PORTLAND MAINE

October 30, 2008

RE: 27 O'Bron St. Building Permits: #08-0138, #07-1188 & #08-0100
CBL: 003-K-011

As you requested, this letter is a follow-up to my final inspection at the above mention property for the associated building permits. The following is a list of outstanding issues that need to be resolved to meet code compliance and close out the permits.

Dougher ~~Residence~~ Residence
Front Deck
Street Elevation
9/7/07

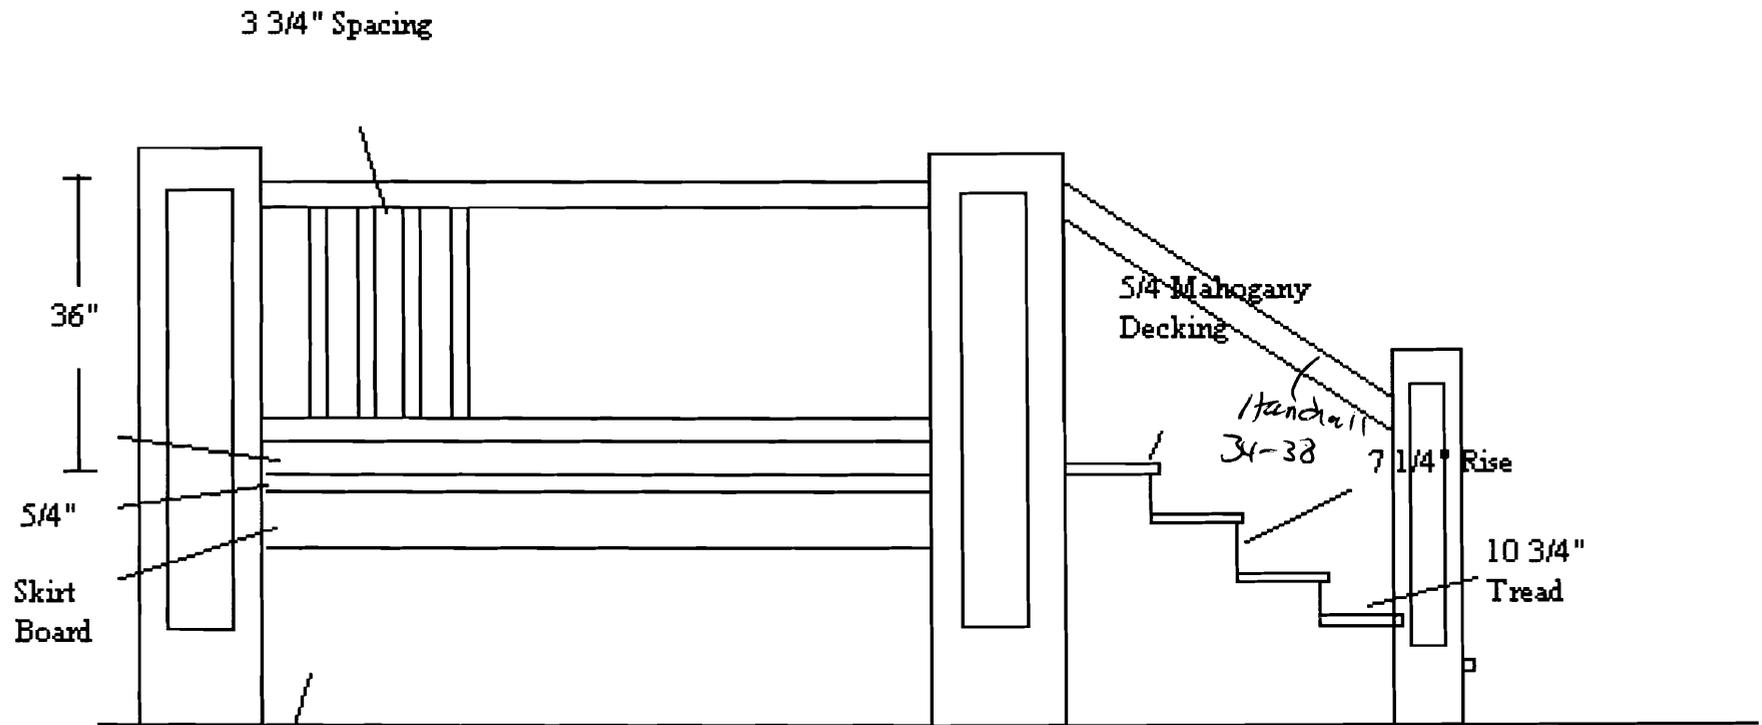
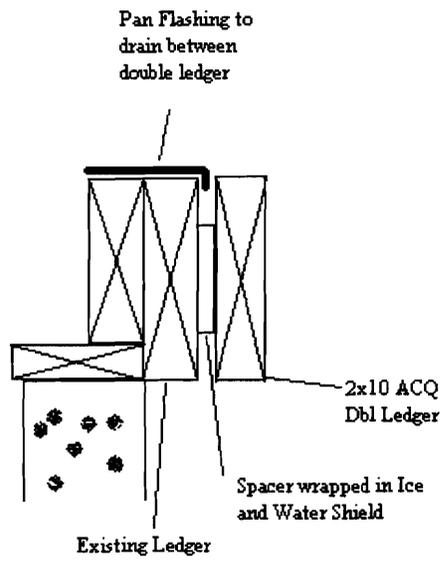
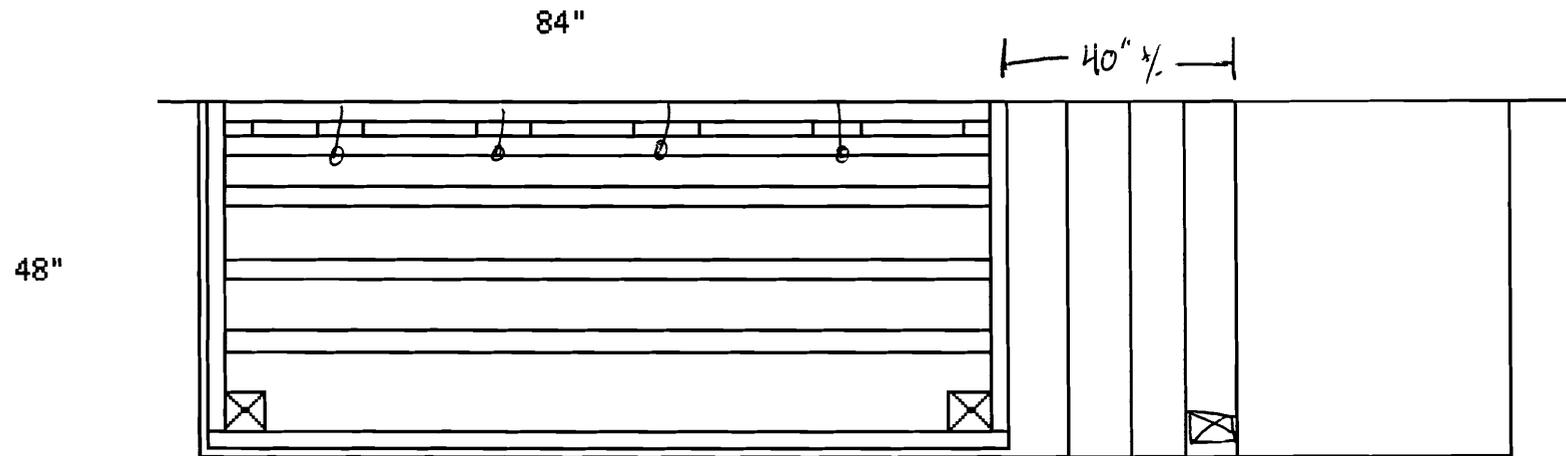
- Install graspable handrail on one side per the code
- Risers are inconsistent beyond the code tolerances
 1. bottom 1st rise – 7-3/4
 2. 2nd rise – 7-1/4
 3. 3rd rise – 7-3/8
 4. 4th rise – 7-3/8
 5. 5th rise – 7-5/8

Framing Detail for
Spiral Stairs for Fernald Residence
27 O'Brien St

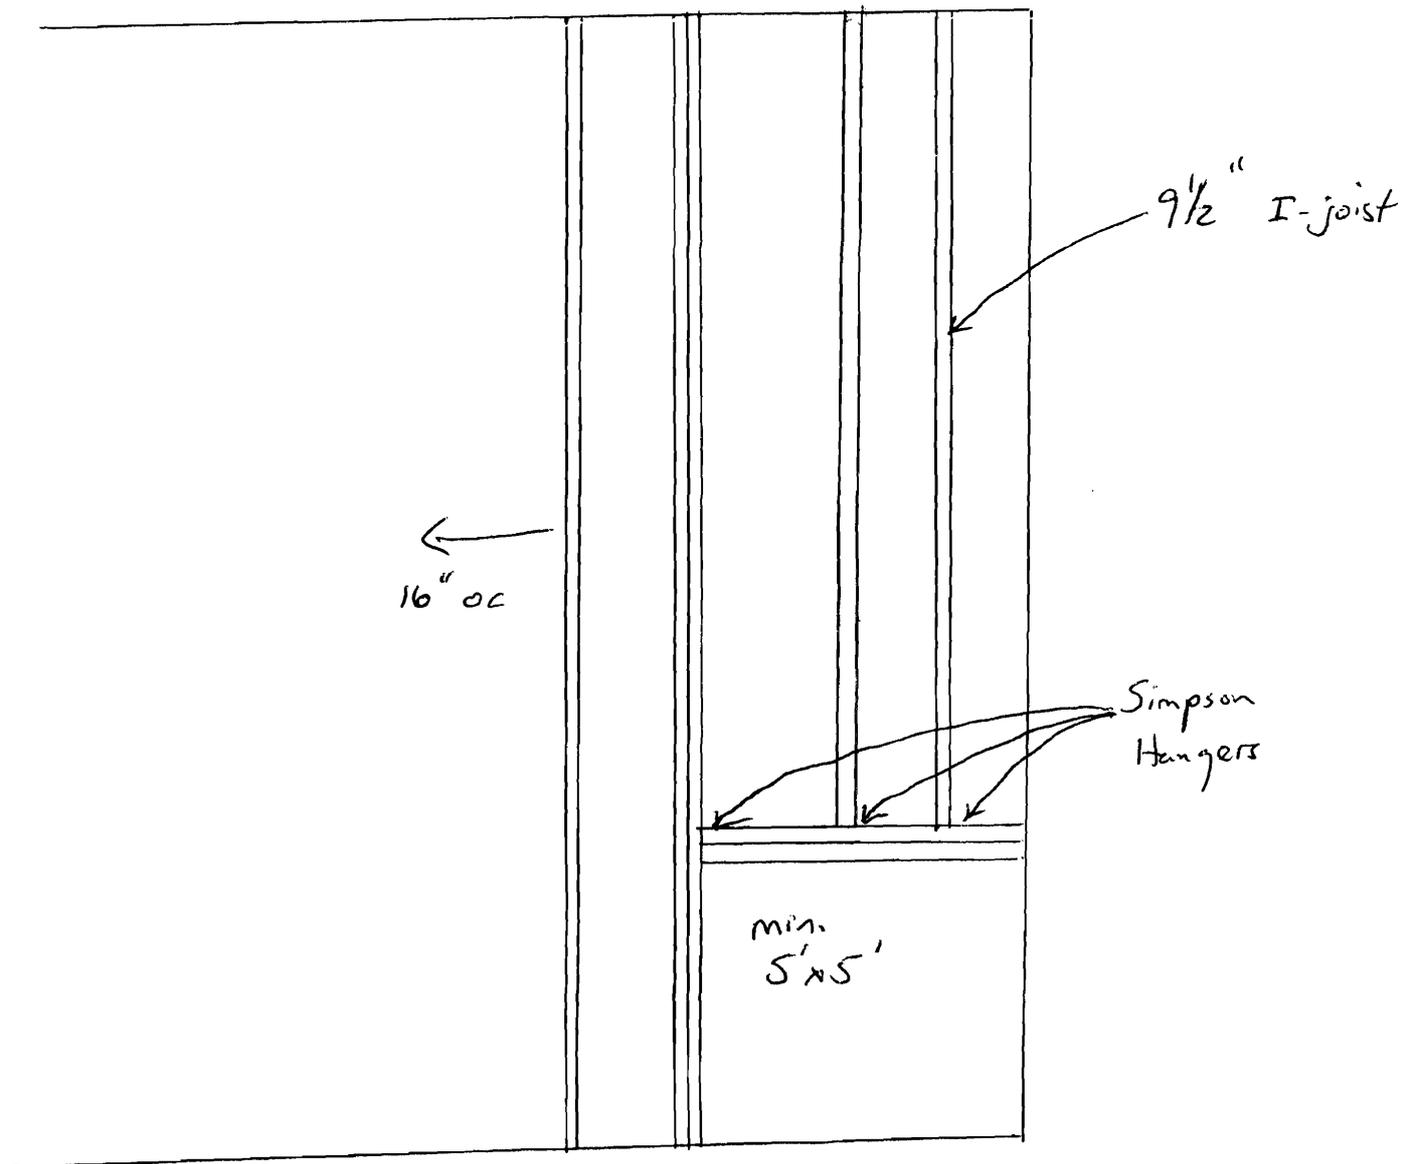
- An amendment to the permit for the change from a spiral stairway to a new built stairway to the 3rd floor including plans & dimensions of stairs, handrails and guardrails. **Note: Troy Morrill will be applying for this on 11/3/08.**
- Handrail on new stair is not a consistent height above the nosing and is not secured adequately.
- Guardrail at the 3rd floor balcony has horizontal cables that are not properly tensioned.
